**KIRKLEES METROPOLITAN COUNCIL
INVESTMENT & REGENERATION SERVICE**

**DELEGATED DECISION TO DETERMINE APPLICATIONS FOR
CONSENT, AGREEMENT OR APPROVAL REQUIRED BY CONDITION**

Reference No: 2021/44/91537/E

Site Address: Dearne Grange Farm, Park Head Lane, Birds Edge,
Huddersfield, HD8 8YA

MATRIX CONSULTING ENGINEERS		Document Reference: 21009-MCE-XX-XX-CA-S-1002		Project Reference: 21-009	
		Suitability: S0 - Initial Status		Sheet No. -	Rev P01
Project Title: PARK HEAD LANE				Date 24/04/21	
Subject 2.0 SKETCHES				By AJH	Chkd LJH
Ref.	2.0 SKETCHES				Output

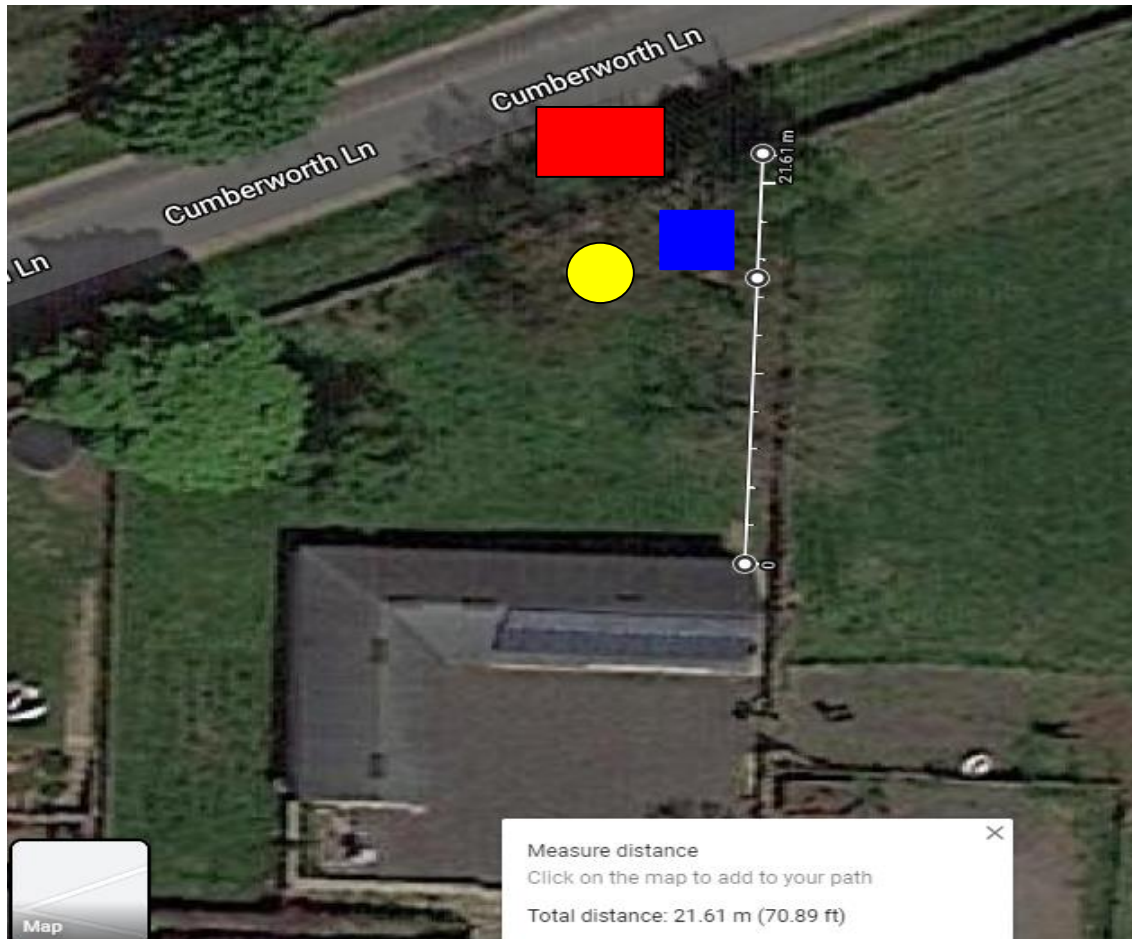
From the provided documents, it is proposed that a Klargestor Domestic BioDisc BA domestic package water treatment plant will be sited parallel to Cumberworth Lane within a few meters of the road to allow for vehicle access. The location of the 2m² drainage field is also denoted adjacent to the treatment plant. This is sufficient to allow Condition 14 to be discharged.
